Located At 51 CONGRESS ST

Job ID: 2011-10-2481-ALTCOMM

has permission to Add a Deck off the 3rd floor over an existing footprint between house & barn, support down through barn provided that the person or persons, firm or corporation accepting this permit shall comply with all of the provisions of the Statutes of Maine and of the Ordinances of the City of Portland regulating the construction, maintenance and use of the buildings and structures, and of the application on file in the department.

RE: 51 Congress Street - #014-K-009 - R-6 Zone - #2011-10-2481

**PROPOSED DECK AT
51 CONGRESS STREET
IN PORTLAND, MAINE**
PAGE 2 OF 2
By Anthony Taylor
in consultation with
Joseph H. Leasure, P.E.
JULY 10, 2009

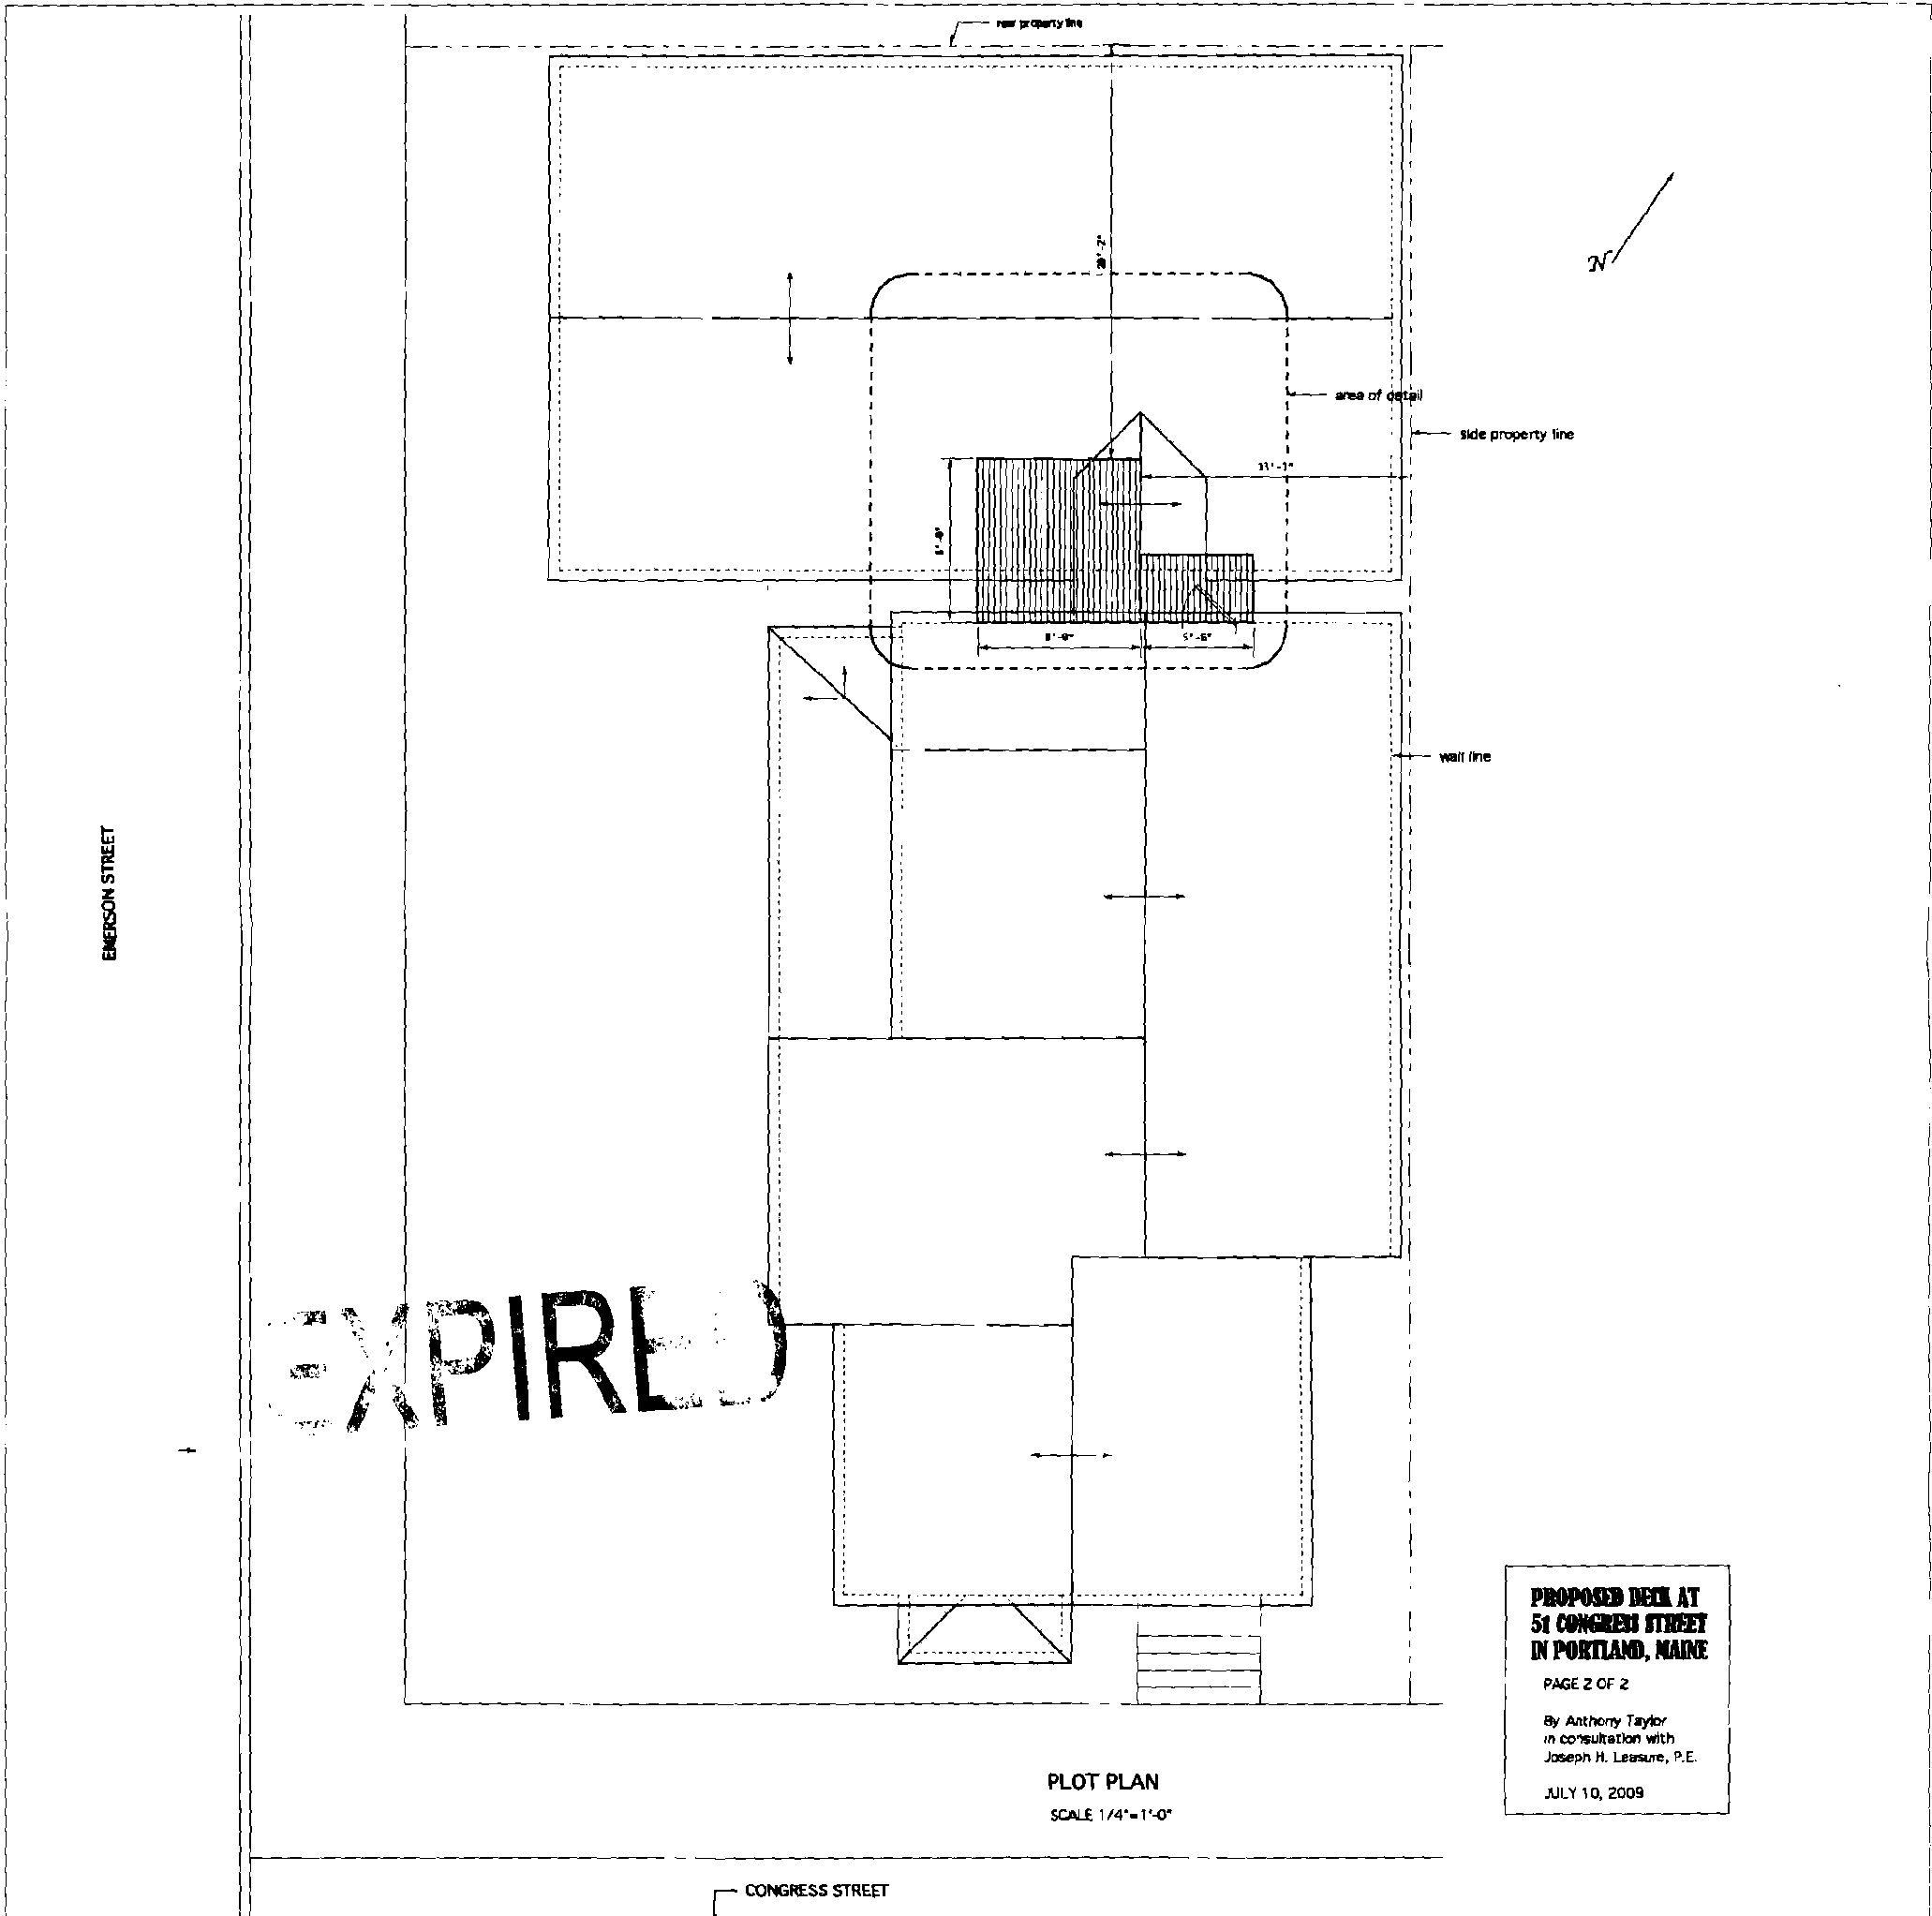
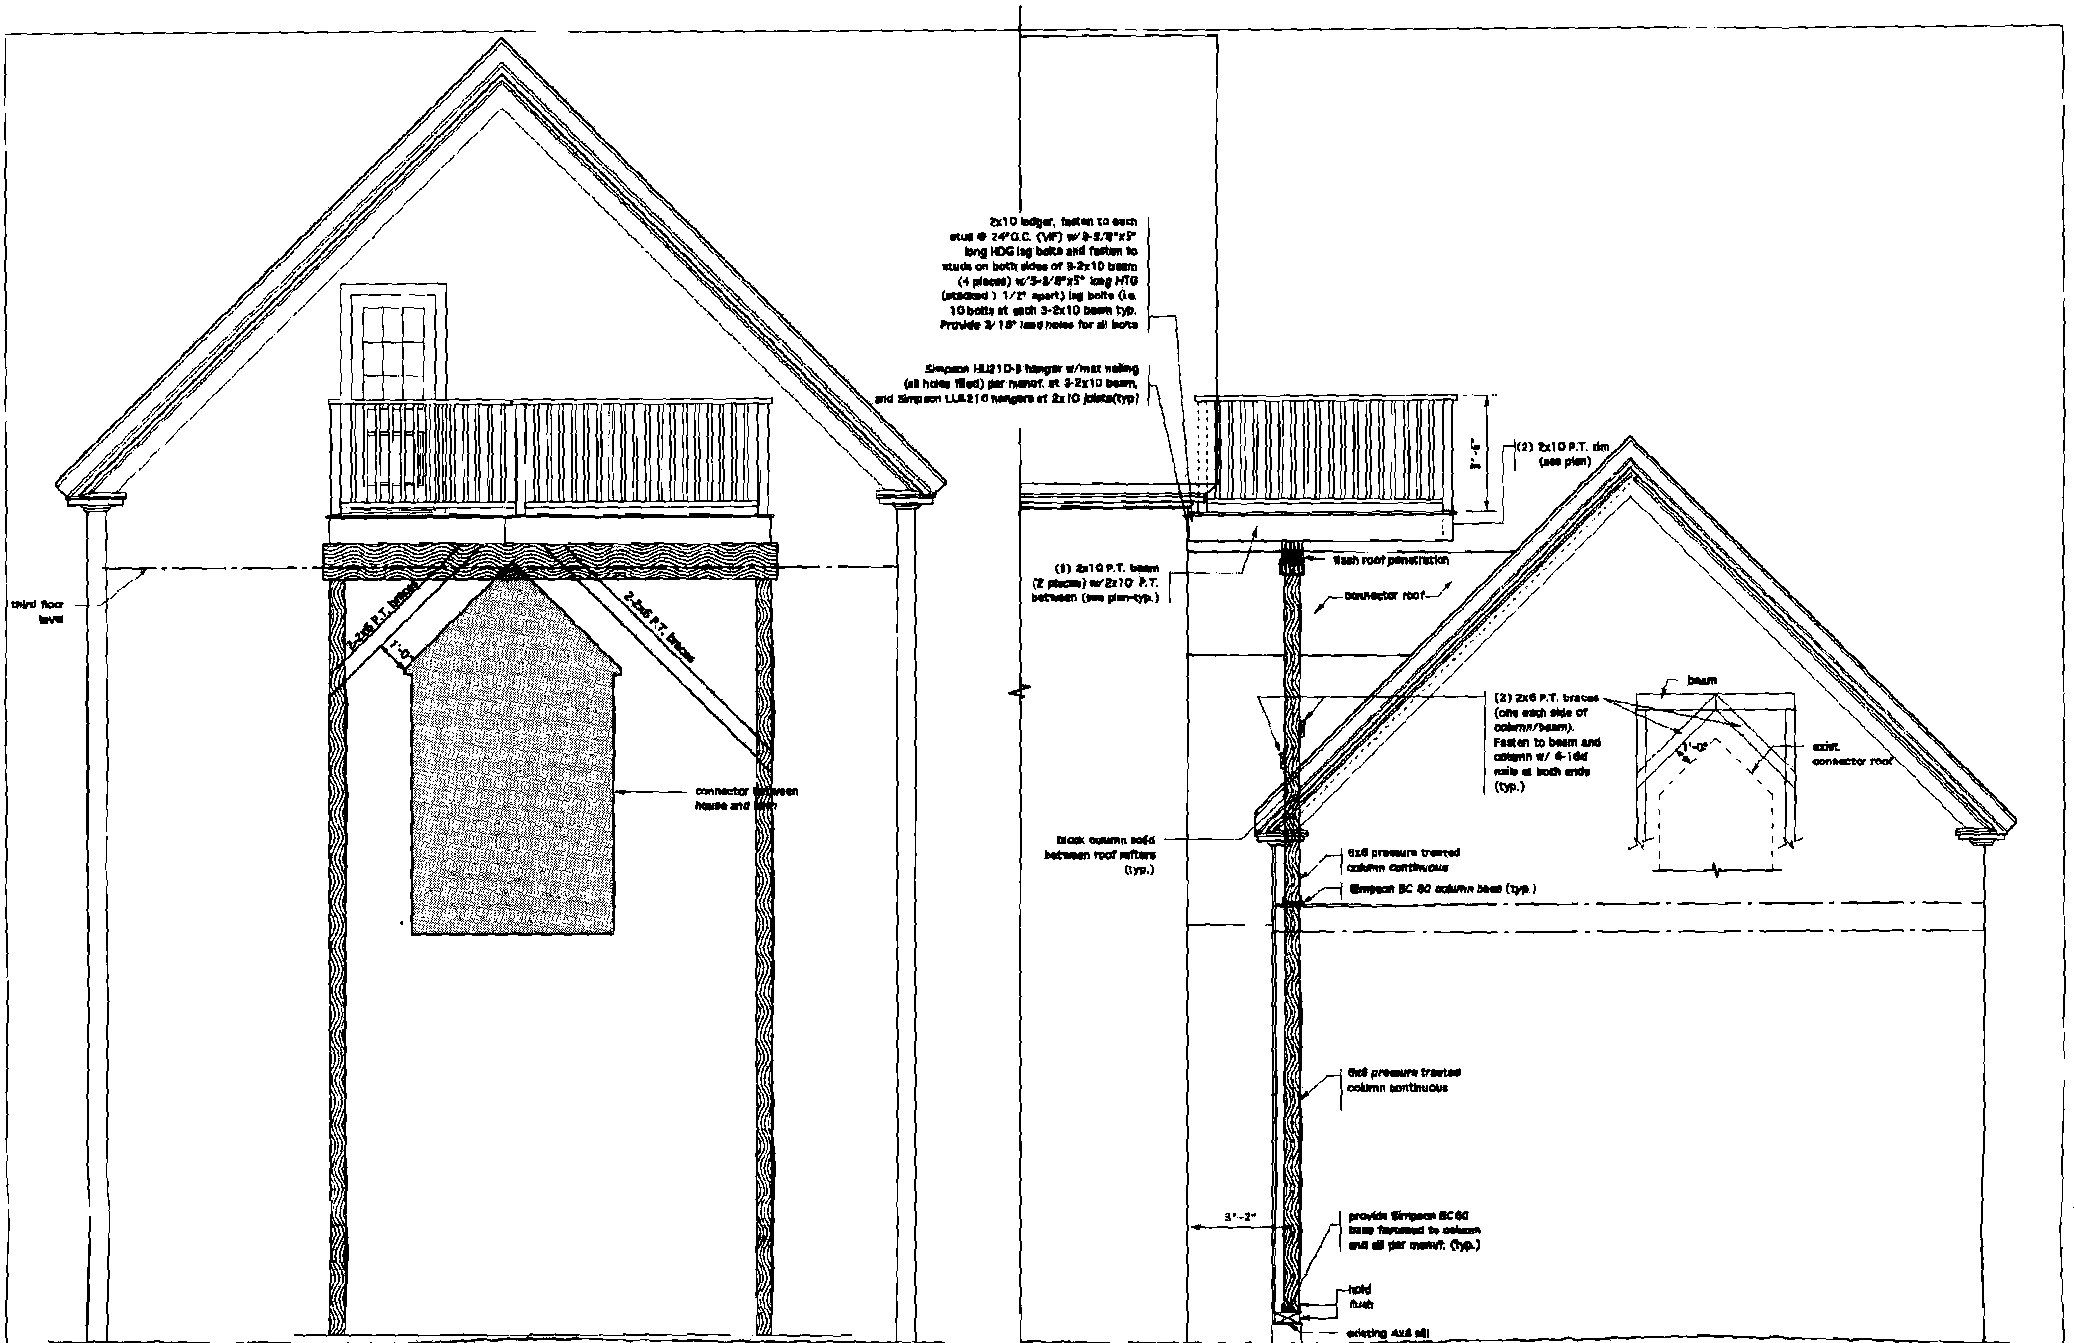
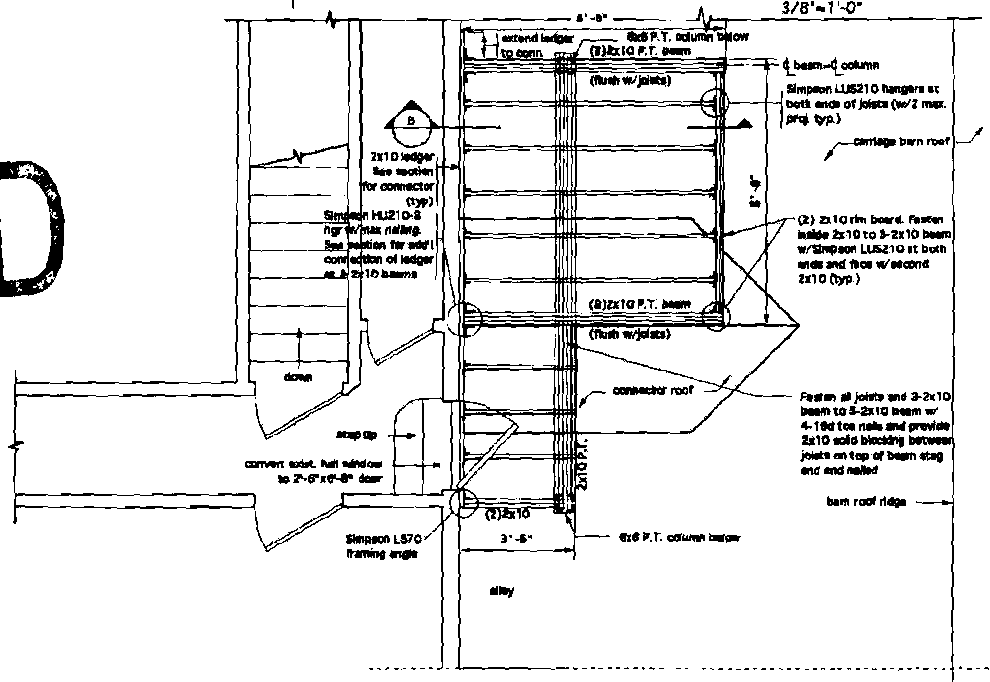
I have reviewed the building application to add an 8'x 8' deck and a 3'6" x 5'6" landing off the third floor of the rear of the building extending over the existing barn. The proposed addition does not meet the lot coverage, so I must deny the application.

51 Congress Street is located in the R-6 residential zone. Section 14-139(d)(3) gives the side setback for a three story structure as 10'. The setback given for the distance from the right side property line to the proposed landing is 9'. Although 10' is required, section 14-433 allows the side setback to be reduced to 5' for an addition if the principal structure existed as of July 19, 1988 and the normal applicable yard requirements can't be met. Since the landing needs to be at 9' because of the existing conditions of the third floor, the side setback can be reduced to 9' under section 14-433.

Section 14-139(e) gives the maximum amount of lot coverage as 50%. The lot is 3960 square feet, so 1980 square feet of the lot can be covered by the footprint of any structure. The total footprint of the existing structures is 2296.78 square feet which is 57.9% of the lot. The proposed deck and landing would add 24.22 square feet to the footprint for a total of 2321 square feet which covers 58.6% of the lot. Since the proposed lot coverage is over the maximum allowable lot coverage of 50%, I must deny the permit.
